**KIRKLEES METROPOLITAN COUNCIL  
INVESTMENT & REGENERATION SERVICE**

**DELEGATED DECISION TO DETERMINE PLANNING APPLICATION FOR  
ADVERTISEMENT CONSENT**

Reference No:	<b>2024/64/92453/W</b>
Site Address:	13-15, Victoria Square, Holmfirth, HD9 2DW
Description:	Erection of non-illuminated signs (within a Conservation Area)
Recommending Officer:	Molly Storer

**DECISION – GRANT ADVERTISEMENT CONSENT**

CLIENT	Mr Yasaratha Herath				
ADDRESS	13-15 Victoria Square Holmfirth, HD9 2DW				
PROJECT	Cafe design				
DRAWING	Signage				
DRAWN	UH	DATE	July 24	SCALE	1.50@A1
DWG No.	2431/01				
STATUS	PLANNING

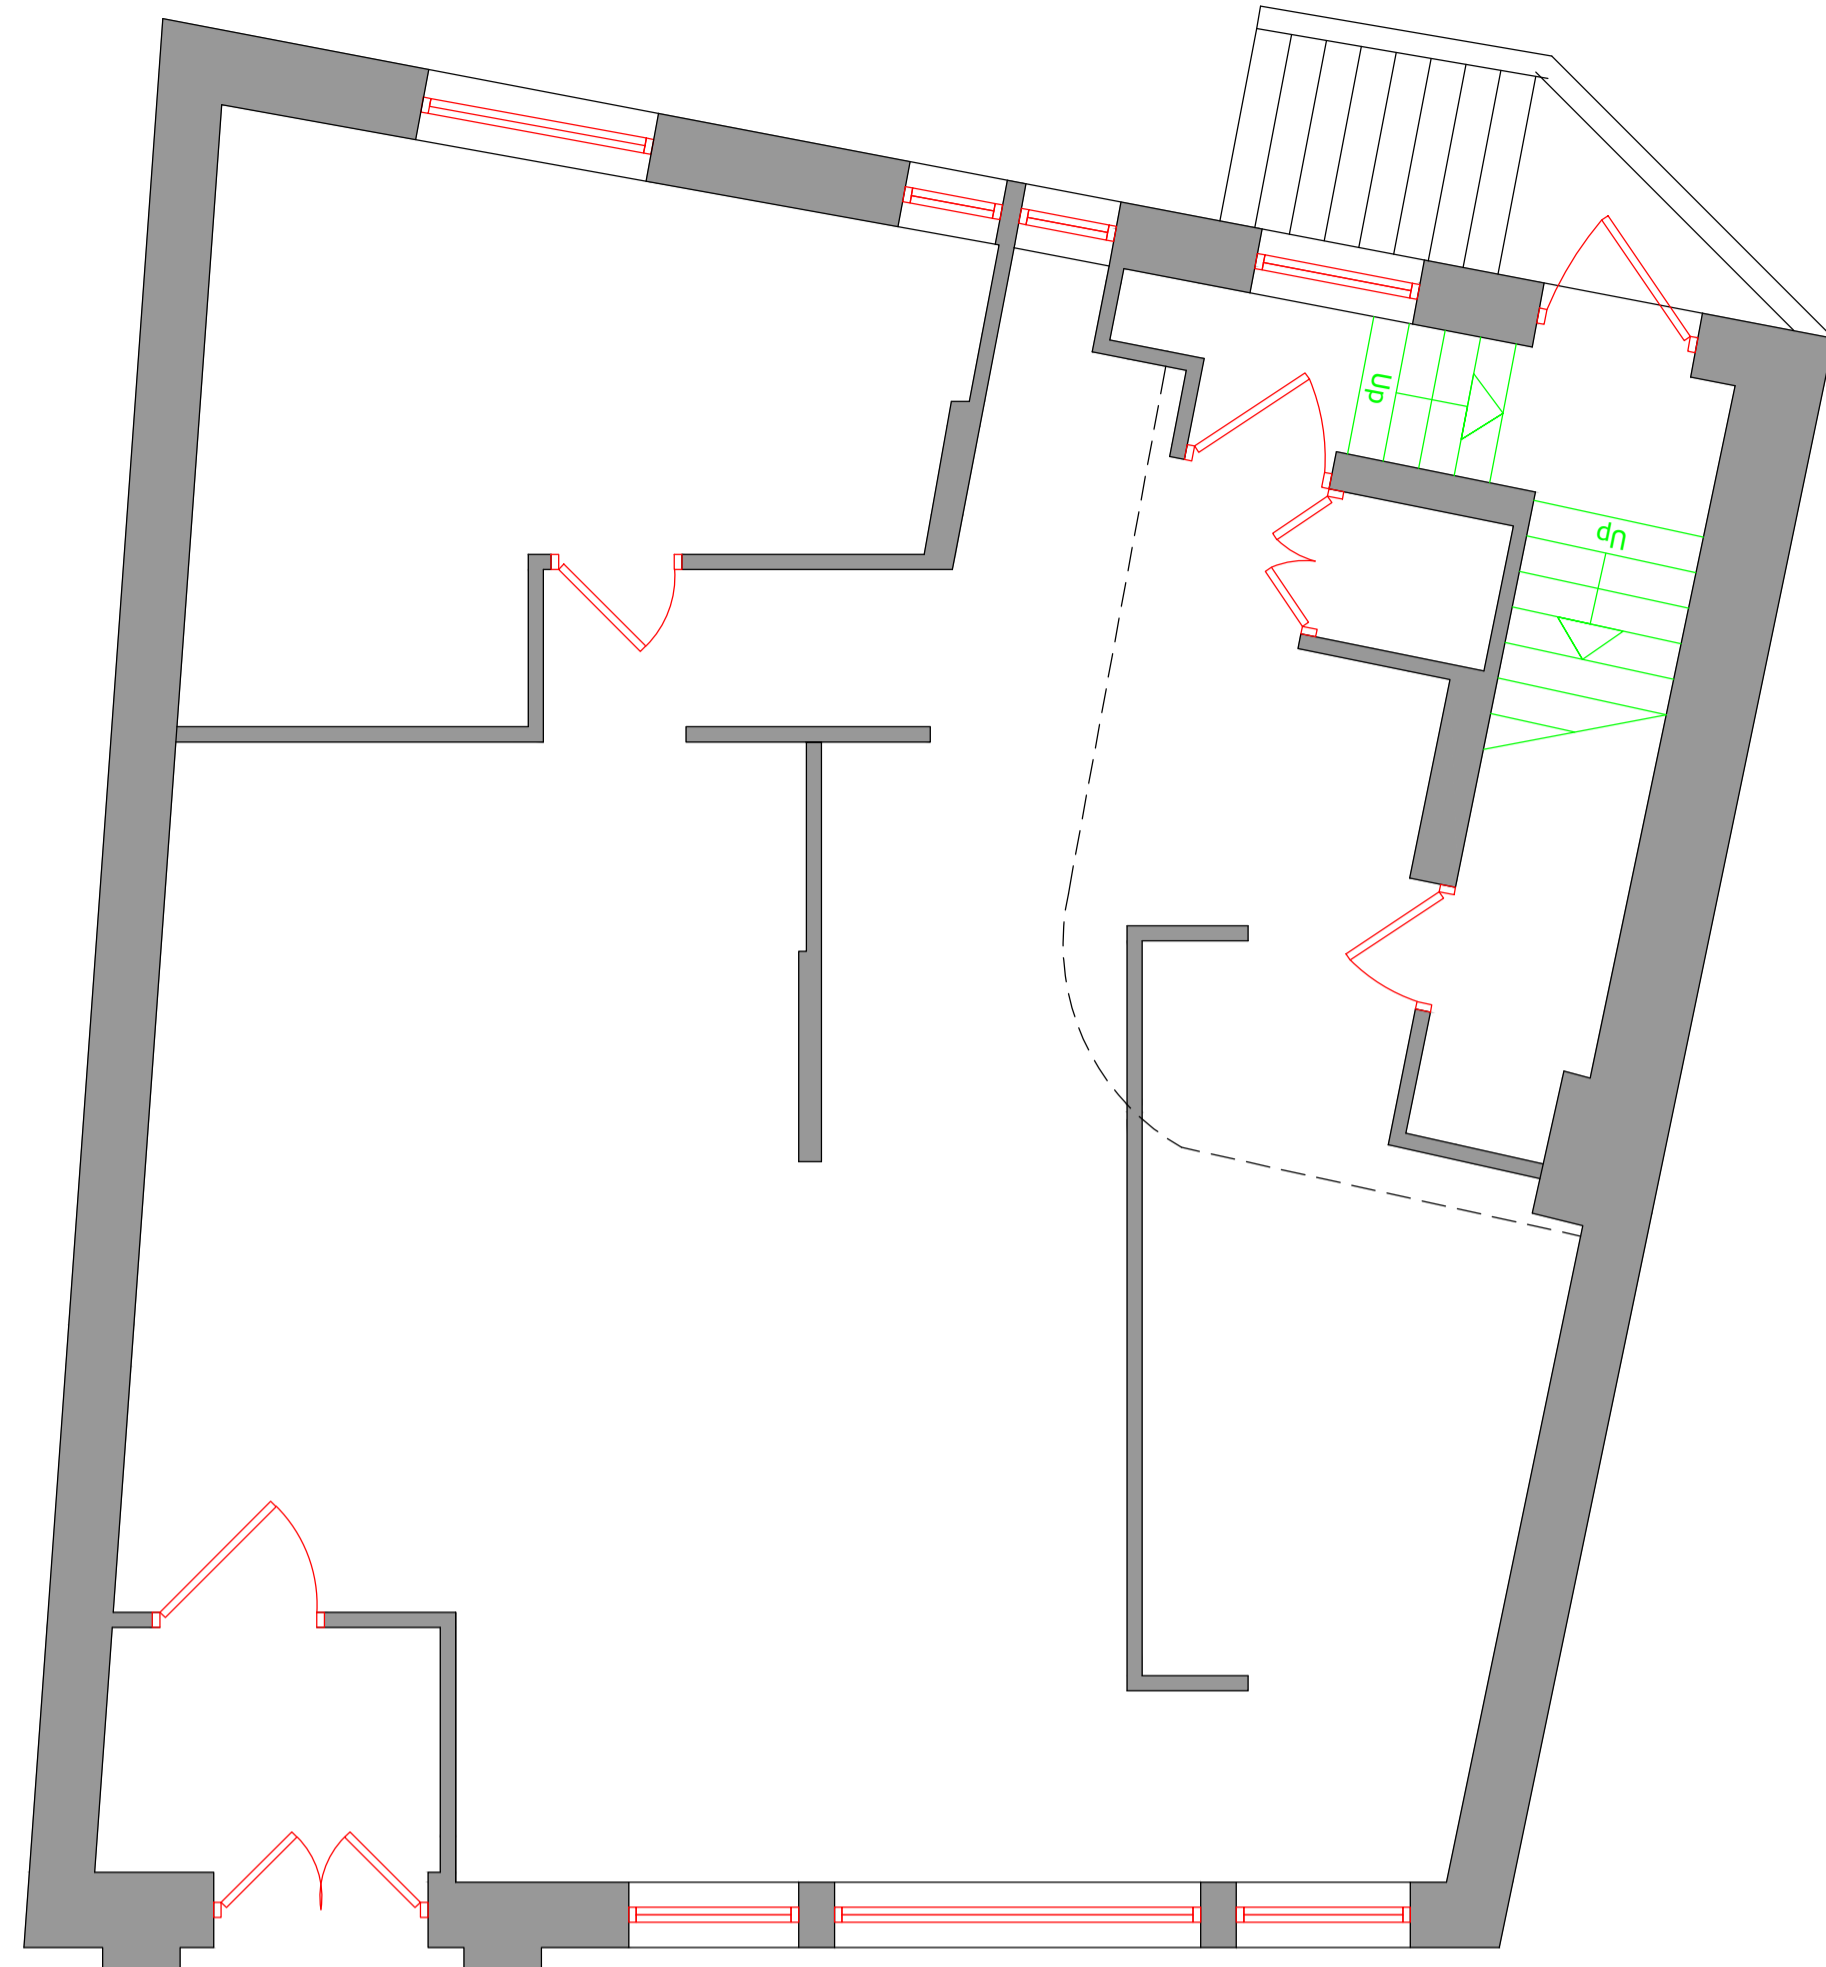
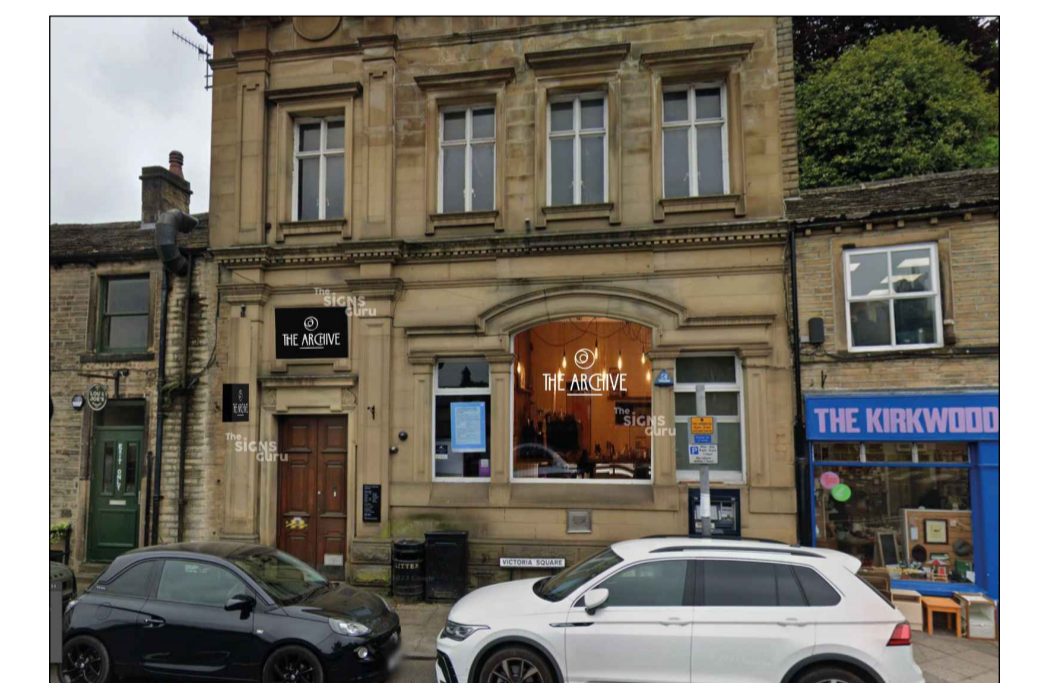
After consulting the Conservation and Design team with regard to this application officers raised concerns in relation to some elements of the scheme. The originally proposed window vinyl was said to add an element of 'clutter' which was not a feature of the existing building which would be overly visible given the prominent location of the building. It was suggested that this be omitted from the plans.

There were also concern with the placement of the projecting sign. It was suggested that this be set back to the previous location of the Barclays projecting sign to make use of these existing fixings as to have minimal impact on the building.

KC Conservation and Design (informal) – With regard to the original plans officers were not supportive of window vinyl to the main elevation. This is because this was not a feature of the existing building and would've been overly visible given the prominent location of the building. They considered that these should be omitted from the proposals.

Officers also had concerns with the placement of the projecting sign. It was suggested that this be set back to the previous location of the Barclays projecting sign to make use of these existing fixings as to have minimal impact on the building.

The agent responded with amended plans which will be discussed in the following report.

Conservation and Design were consulted again with amended plans and were satisfied that these plans overcame previous concerns.

K.C. Conservation and Design have been informally consulted as part of this assessment and after amended plans were received that reduced the 'clutter' on the window of the main elevation and set back the projecting sign to the location of the Barclays projecting sign to make use of existing fixings it was
